KITTITAS COUNTY
DEPARTMENT OF PUBLIC WORKS

MEMORANDUM

TO: Noah Goodrich, Staff Planner, Community Development Services
FROM: Randy Carbary, Planner II
DATE: December 11, 2006
SUBJECT: Koren Short Plat

KOREN SHORT PLAT
PART OF SECTIONS 8 AND 9, T. 19 N., R. 15 E., W.M.
KITITAS COUNTY, WASHINGTON

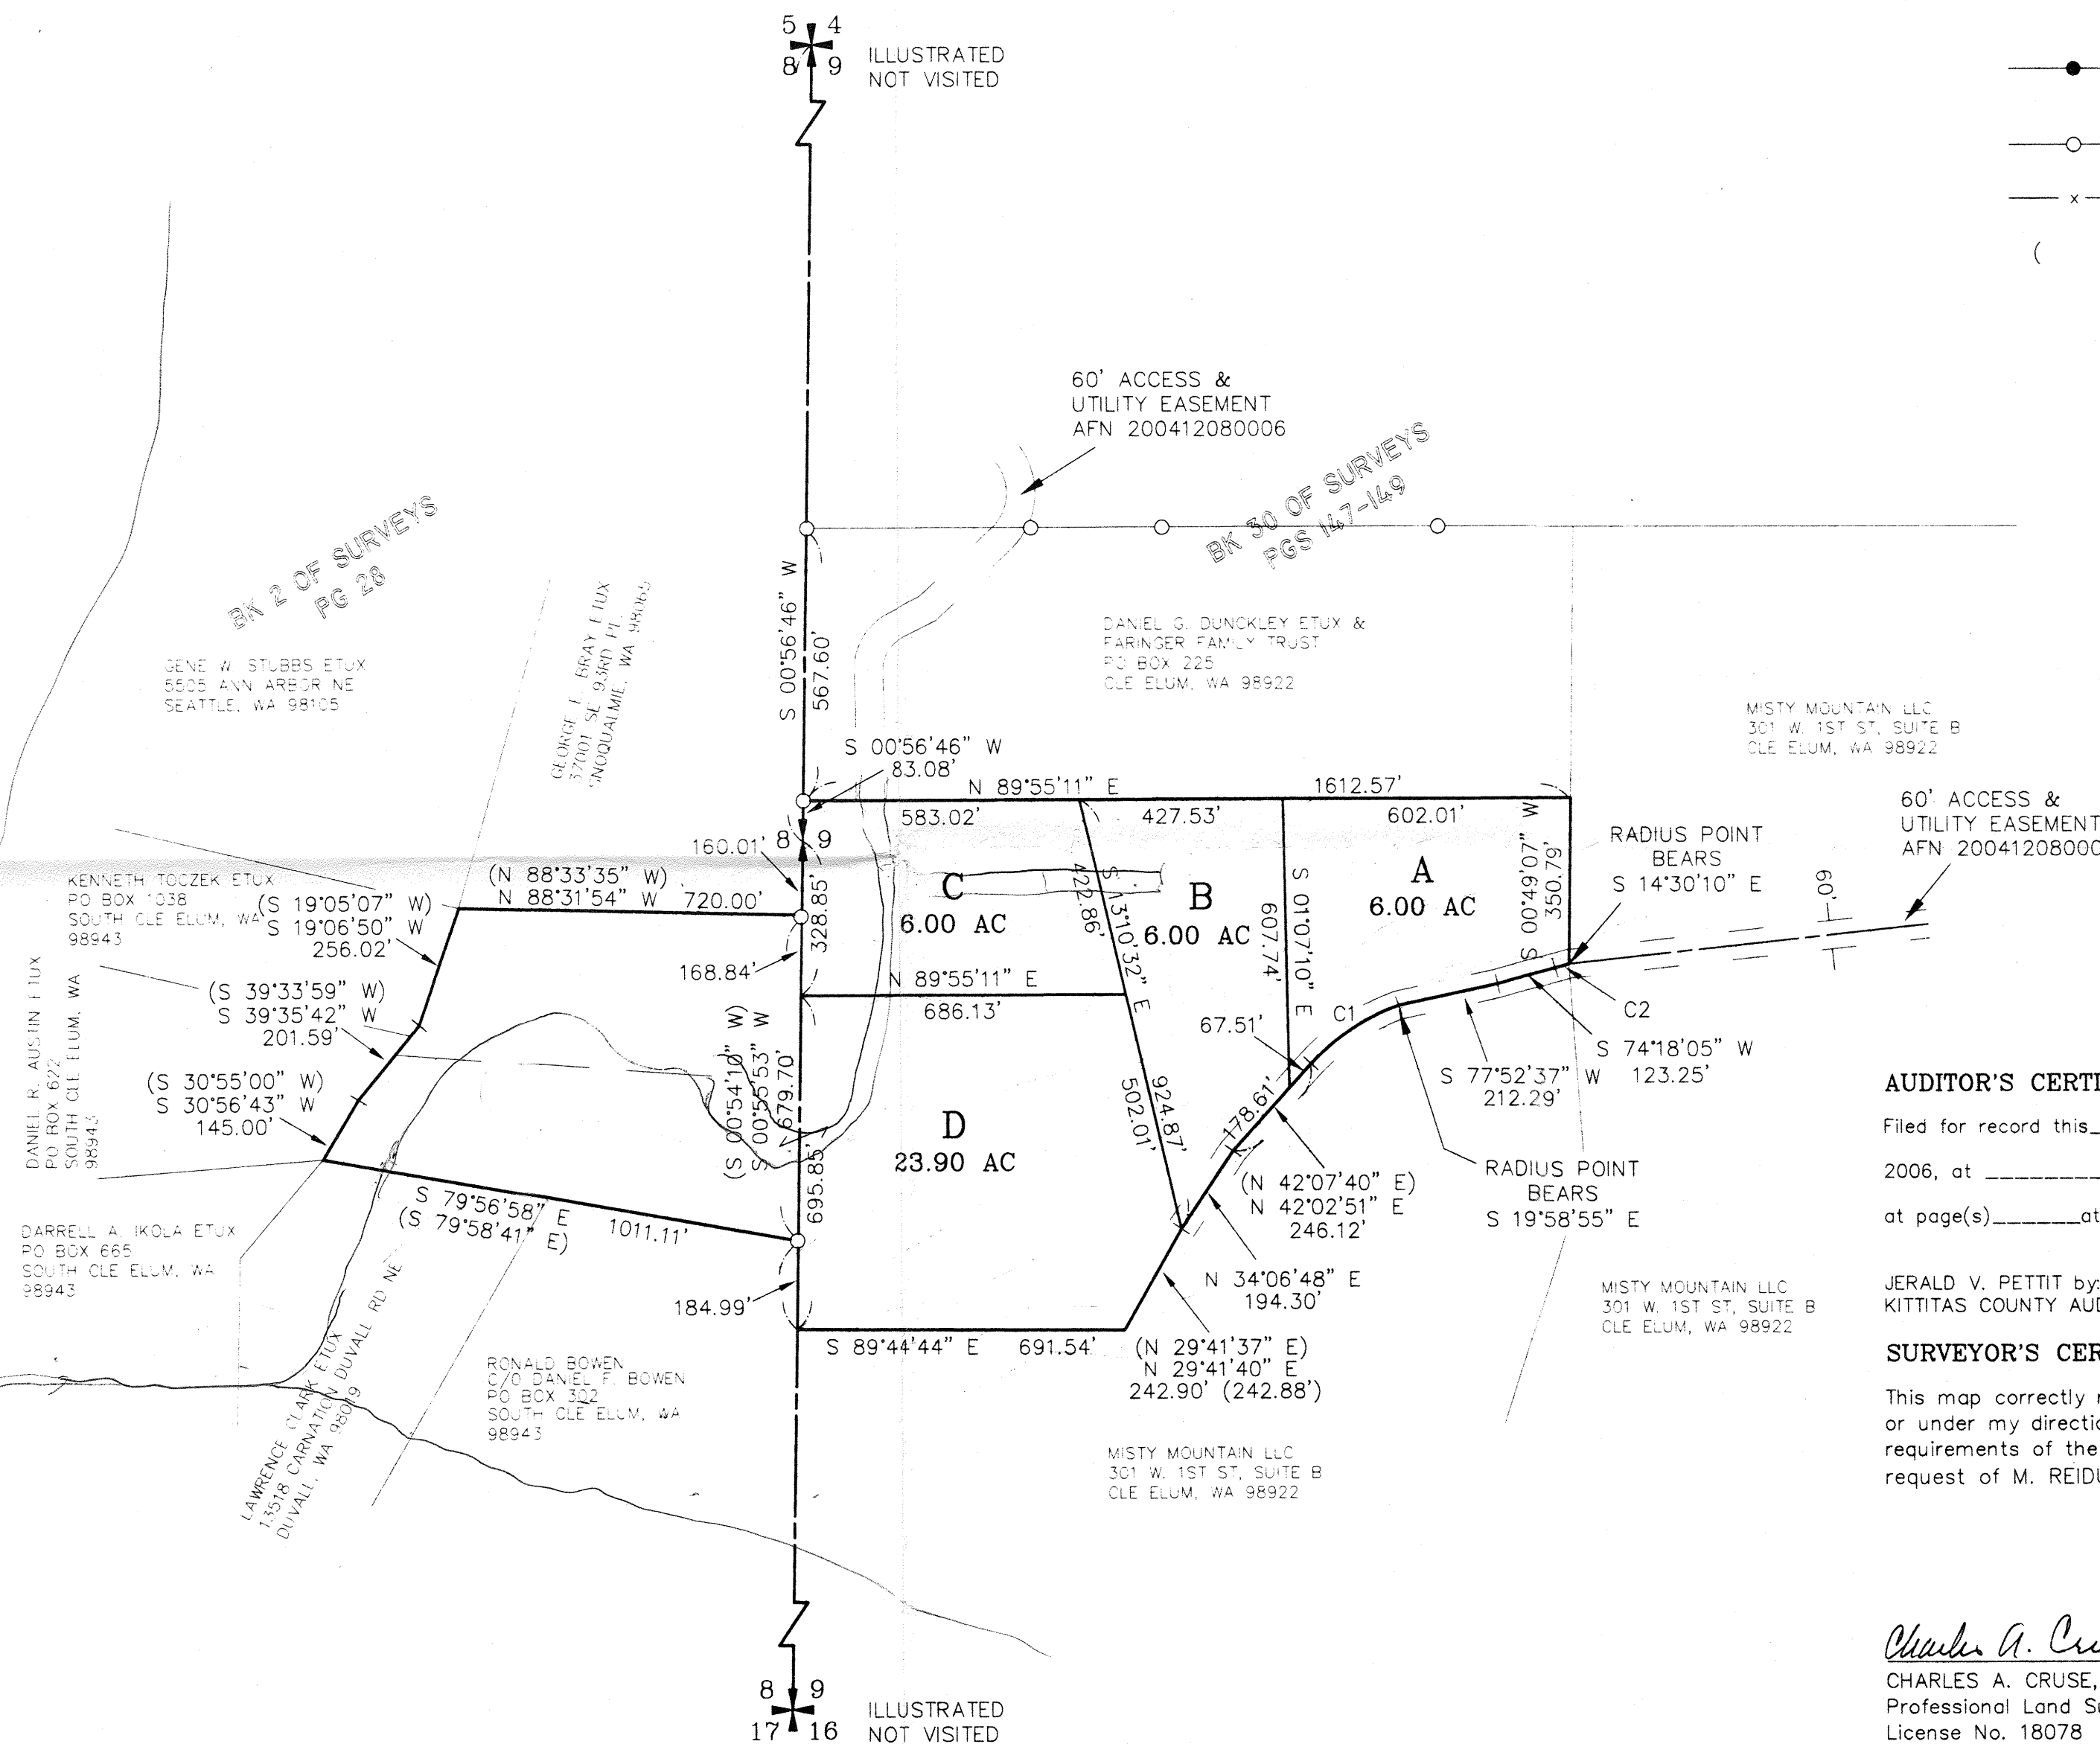
1. Second Access: Current Kittitas County Road Standards requires a second access for more than 40 lots. The specific road width shall be based on the total number of lots served by the road system and the average size of the lots served by the road system. The second access shall be required prior to the issuance of a Building Permit for any of the lots within the Koren Short Plat. Per Kittitas County Code 12.01.095 General Requirements:

At least two ingress-egress routes which are interconnected are required for all roads that serve more than 40 lots.
